Havering
LONDON BOROUGH

London Borough of Havering (20025659) – Written Summary of Hearing Oral Submissions

Thank you for the opportunity for LB Havering to attend and give evidence and the Examination Hearings for the M25/J28 Improvement Scheme Development Consent Order (DCO).

Figure 4-3: 2022 PM peak changes in traffic flows near Gallows Corner

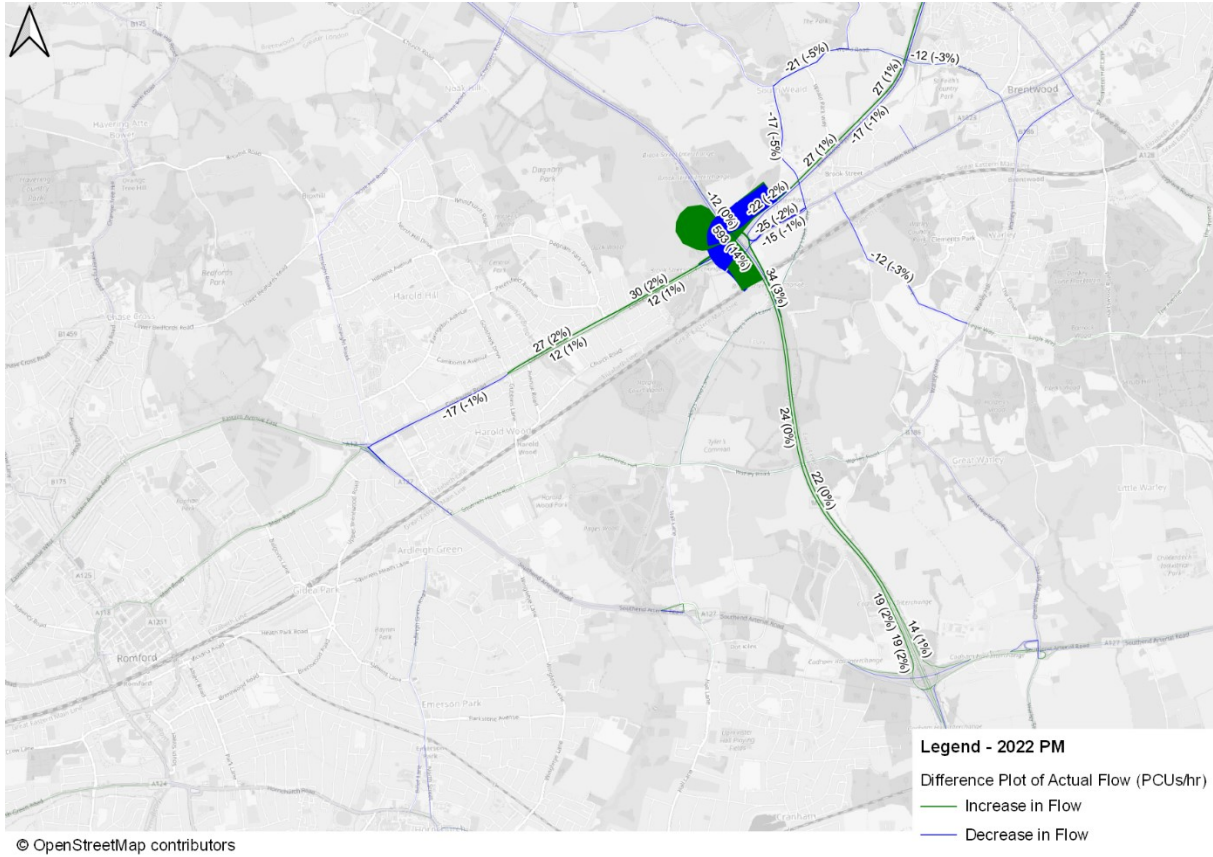
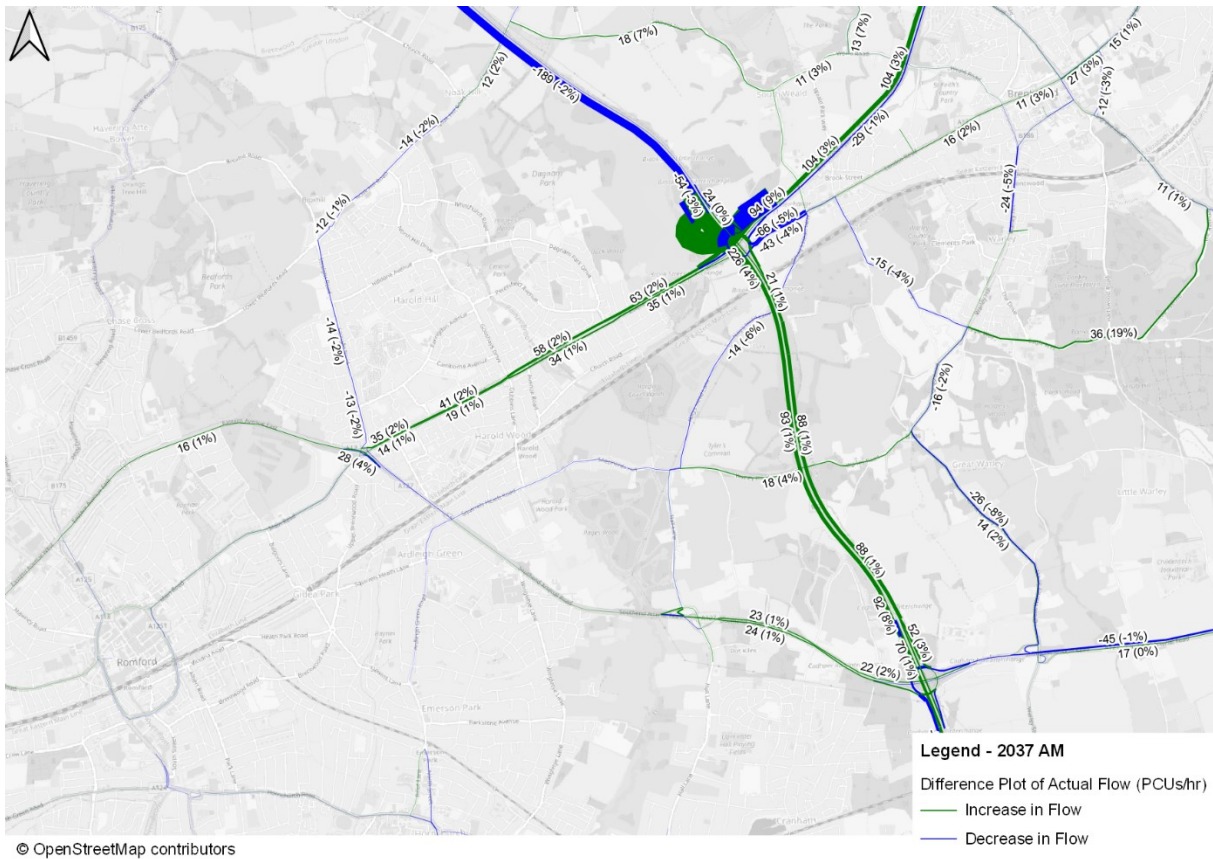
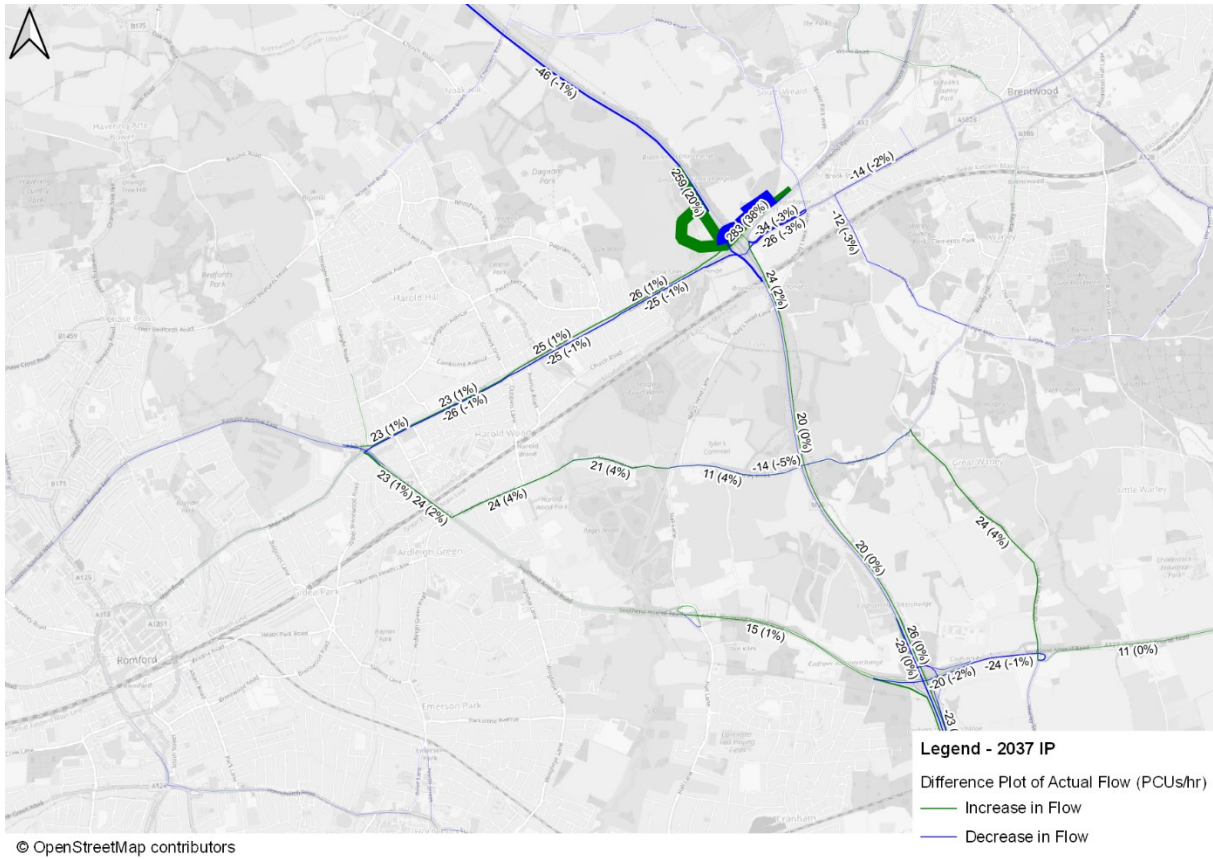
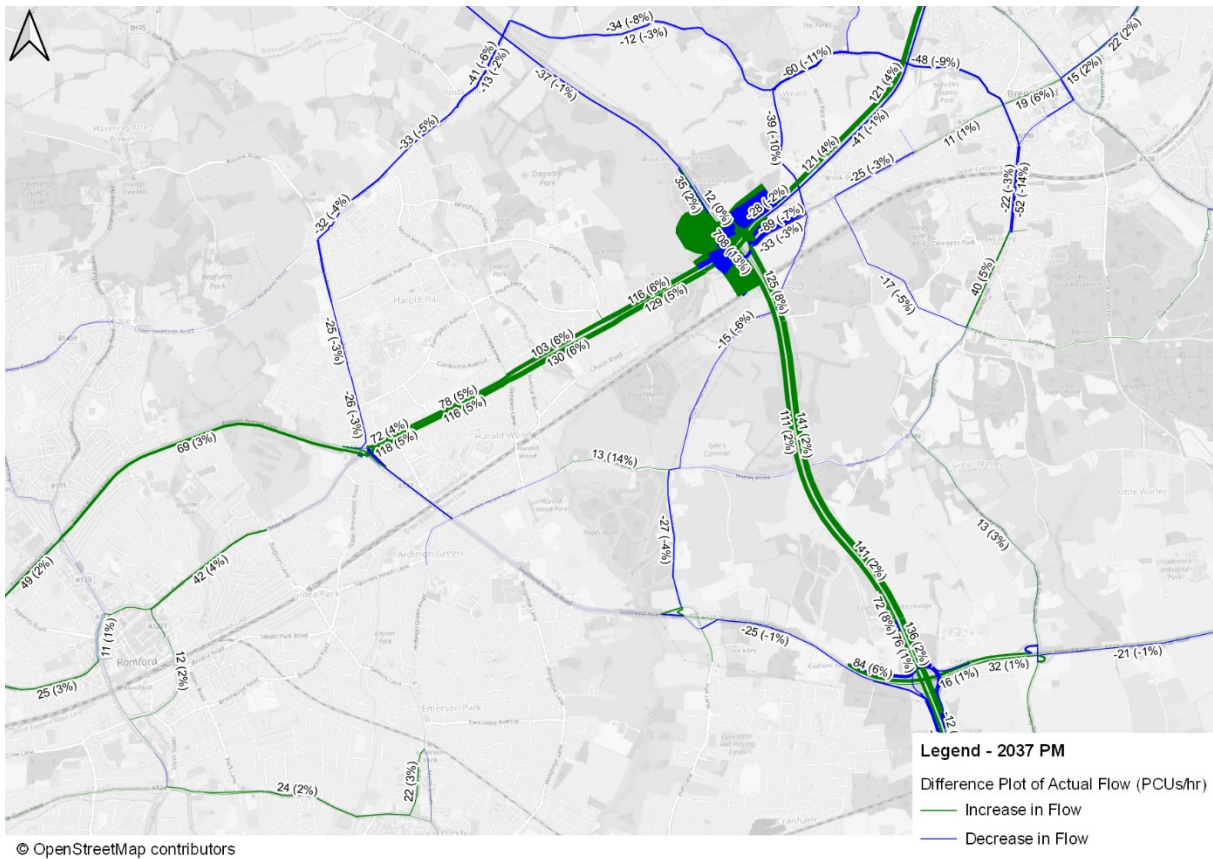
The Council would like to see the Microsimulation model extended to include Gallows Corner junction. Whilst it is noted that the strategic model used by the Applicant covers this junction, this only looks at the junction from a traffic flow perspective and not how the junction will operate in future years. LB Havering would like to see the microsimulation model extended to include Gallows Corner.
